26 November 2019

File No: 2019/578697
Our Ref: R/2017/25/A
Your Ref: SSD-8924 & SSD-8925

Request for advice – The new Sydney Fish Markets – Concept and Stage 1 (SSD-8924) and Stage 2 (SSD-8925)

Photomontage of New Sydney Fish Market from outside Glebe Rowing Club.

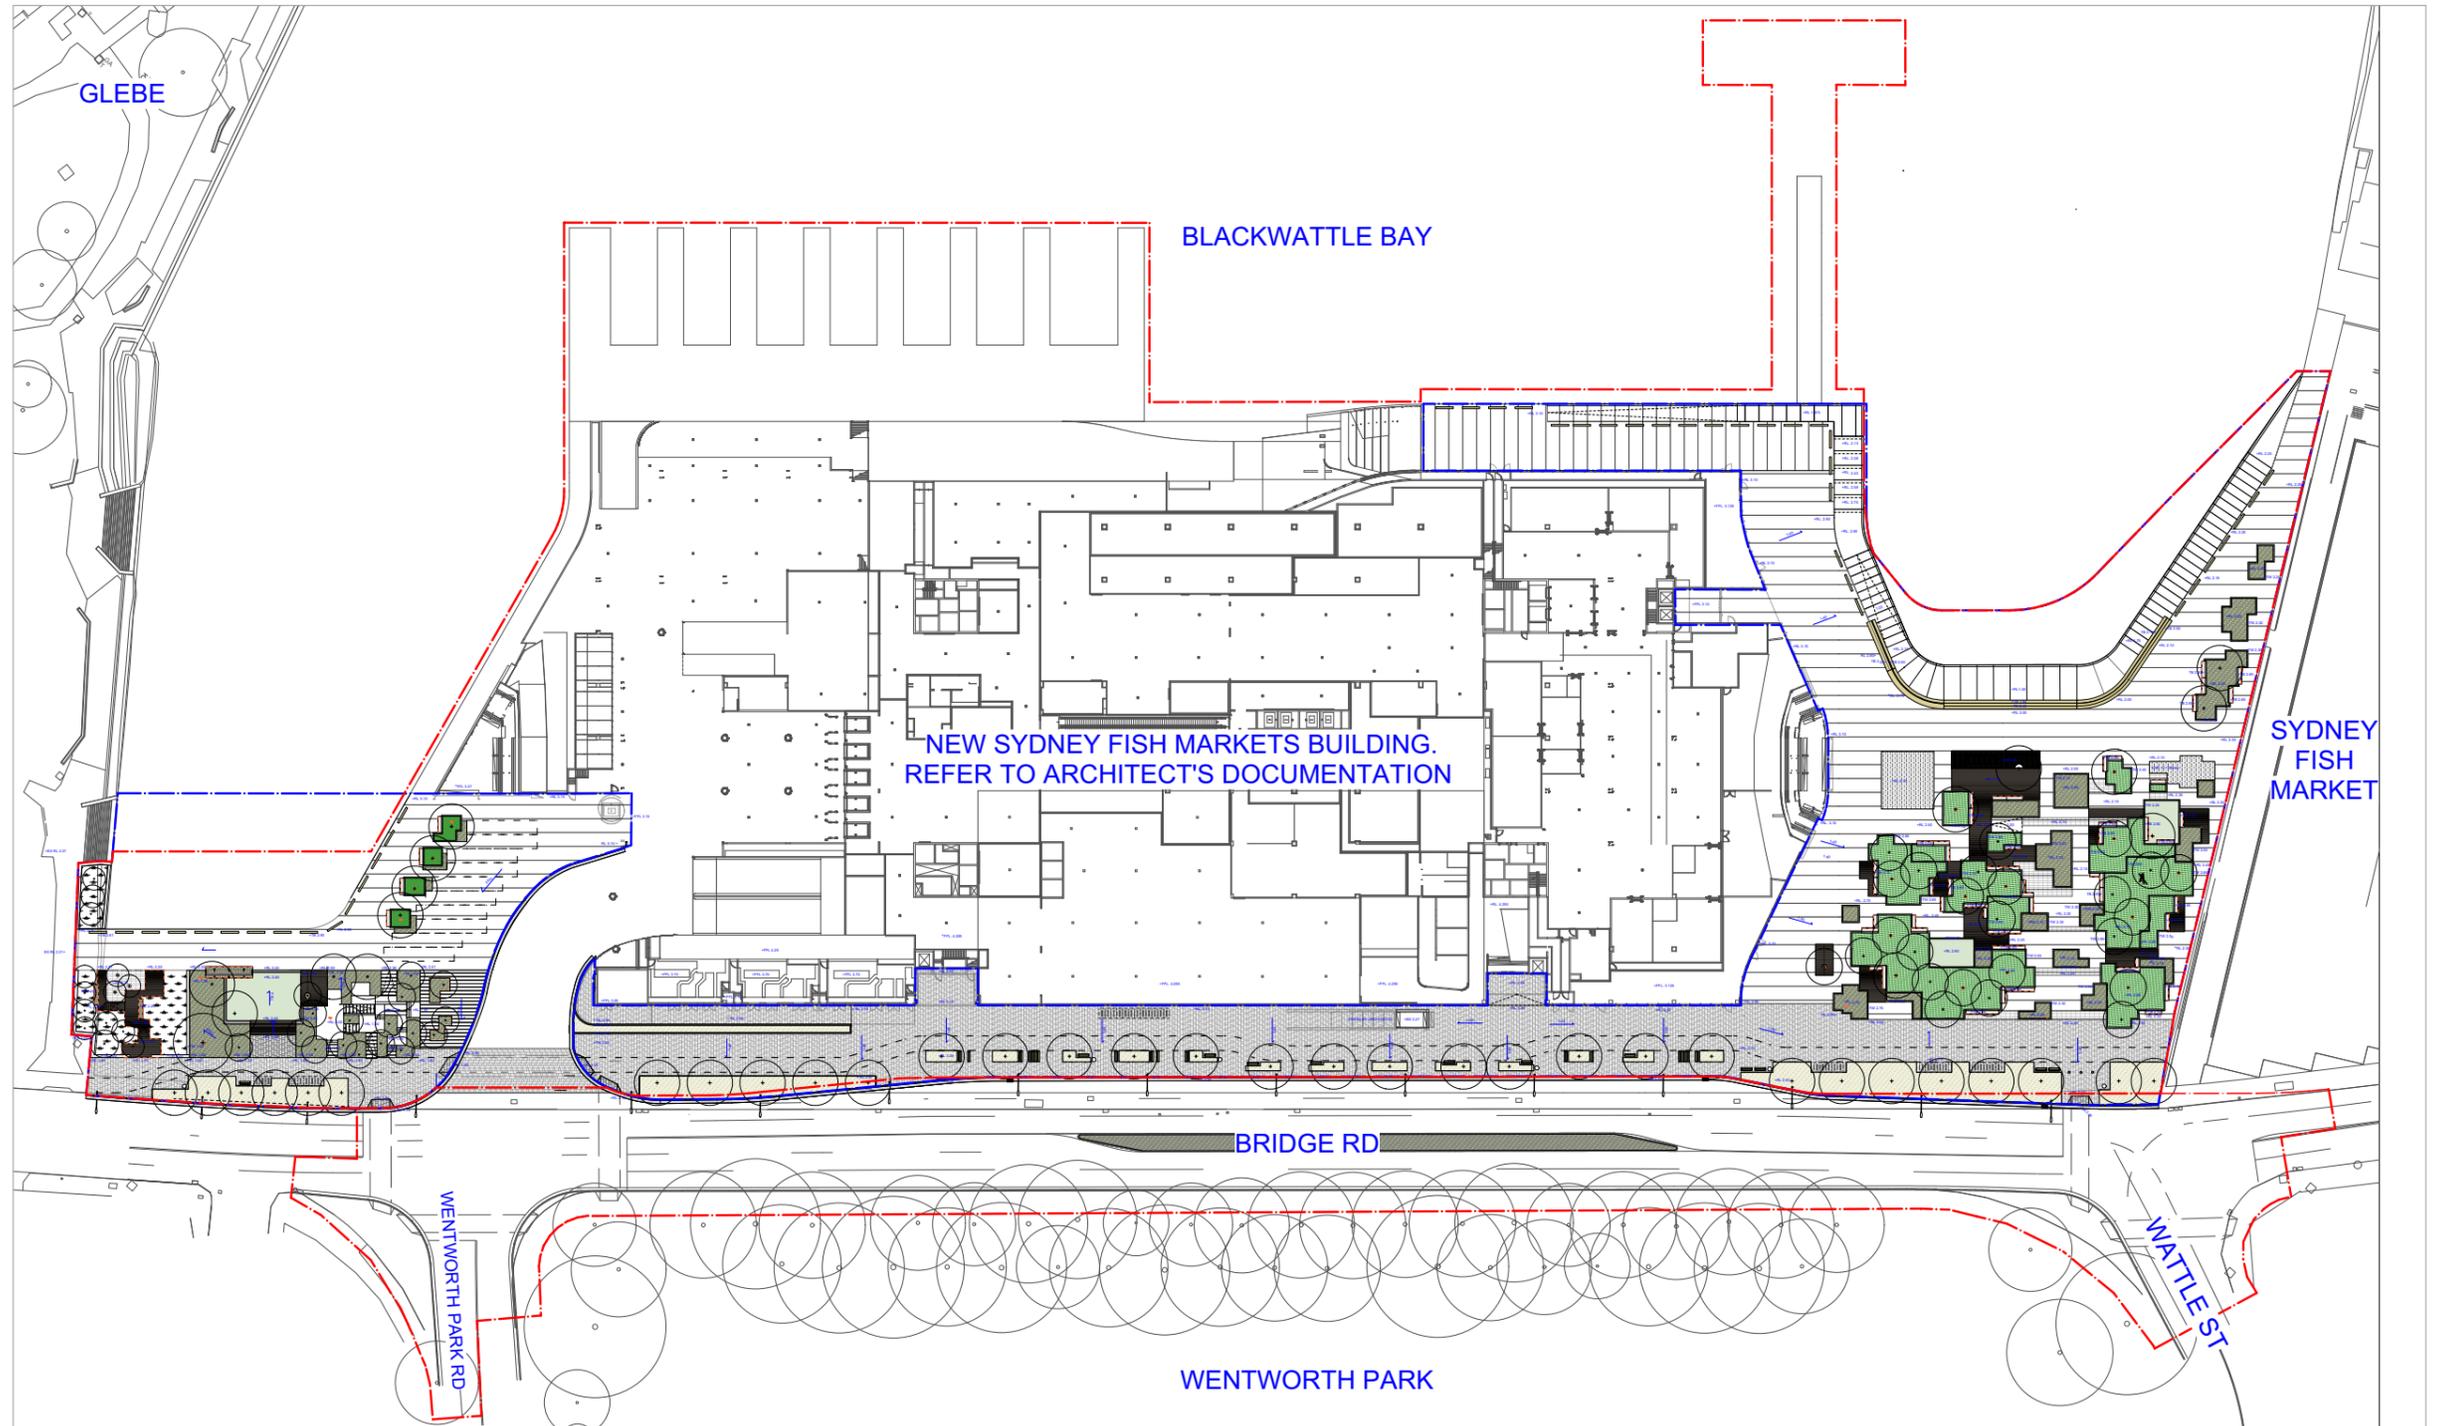
Further, the existing group of significant fig trees are highly visible from a wide vista of lands surrounding Blackwattle Bay looking south as well as areas looking north. The proposed development results in scenic quality impacts and public view loss to an existing strong landscaped public edge (“green band”) along with foreshore with direct connection to Wentworth Park resulting from the scale of the proposal as depicted in the images below from the submitted VIA.

The proposal partially conceals significant water views north from Wentworth Park, and views looking south from the surrounding visual catchment. The proponent is encouraged to soften the public domain on the northern elevation with robust landscaping that withstands wind impacts.
